9 December 2024

Our reference: COR2017/32/1/7

Meadowbank School Project - Modification 6 - Modification 6 (SSD-9343)

Modification to conditions to amend out of hours use by external parties including conditions E1, E3 and E9.

**LEVEL 2 FLOOR PLAN**

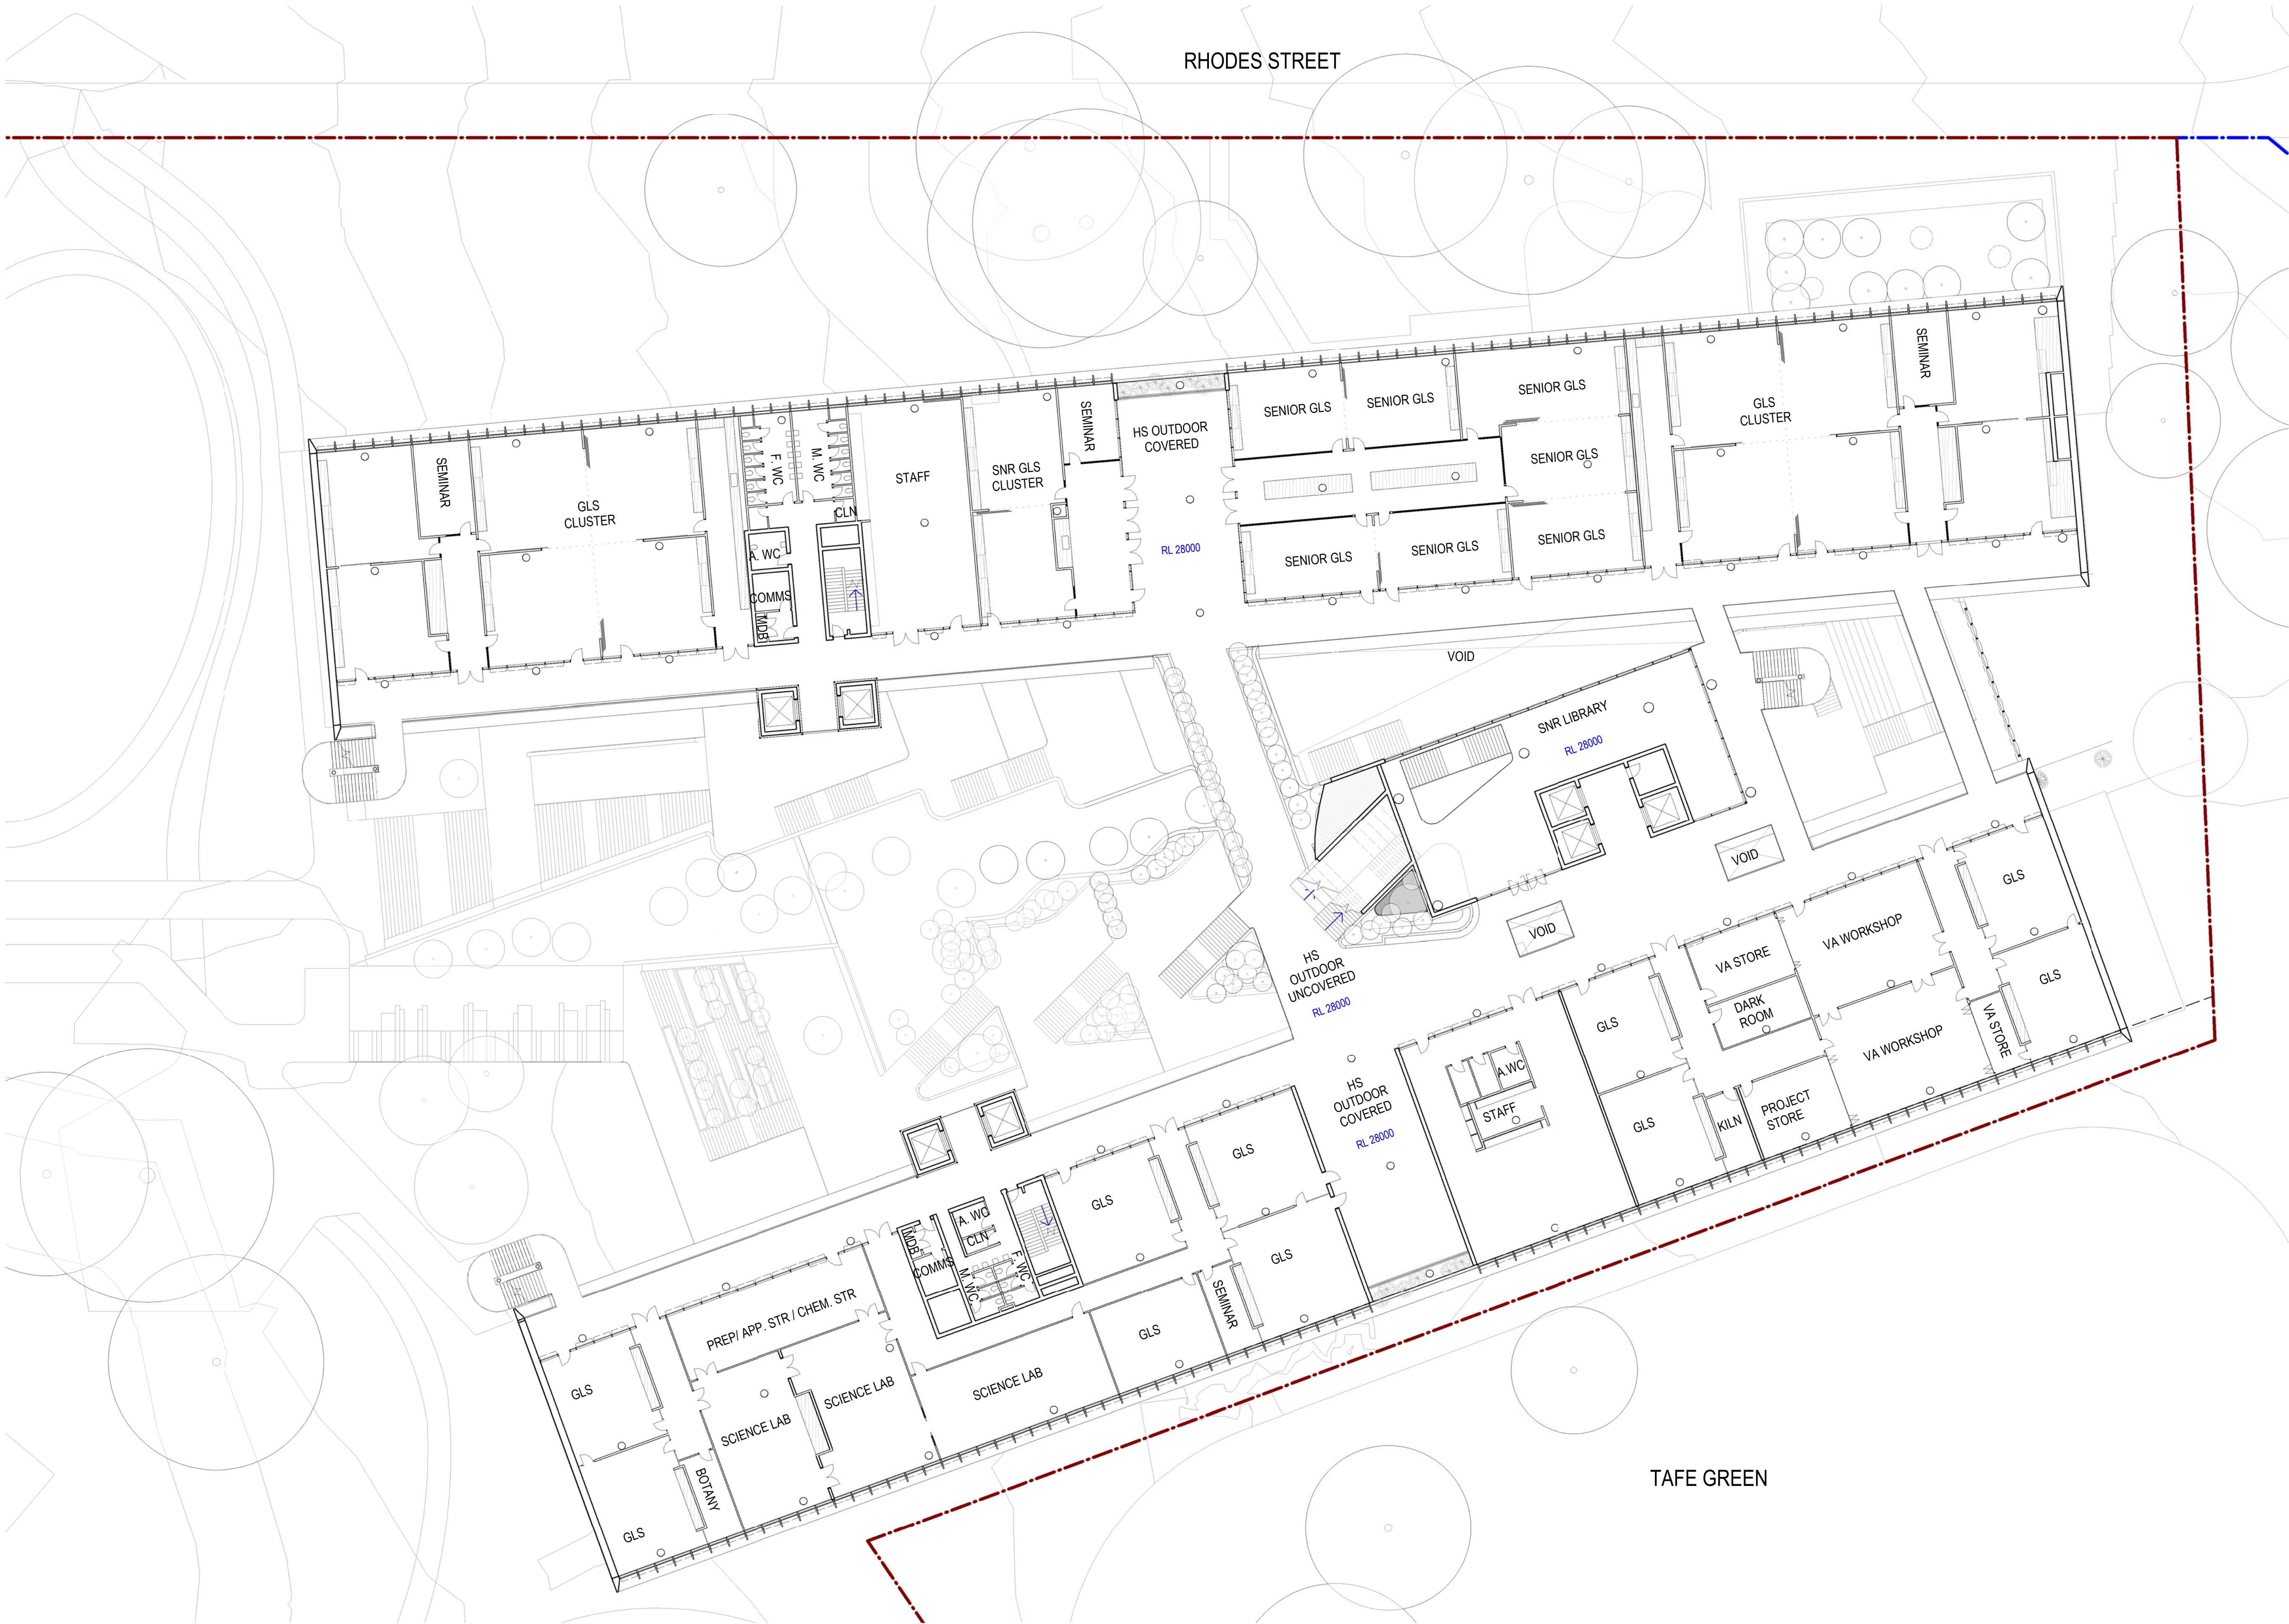
E3. Use of school facilities by external parties (community use) shall be restricted to between the hours of 7am to 10pm only. No loud amplified music can be played in any external sporting area. The use of external PA systems must be kept to a minimum. Primary and High School outdoor uncovered areas on Level 2 should not be used.
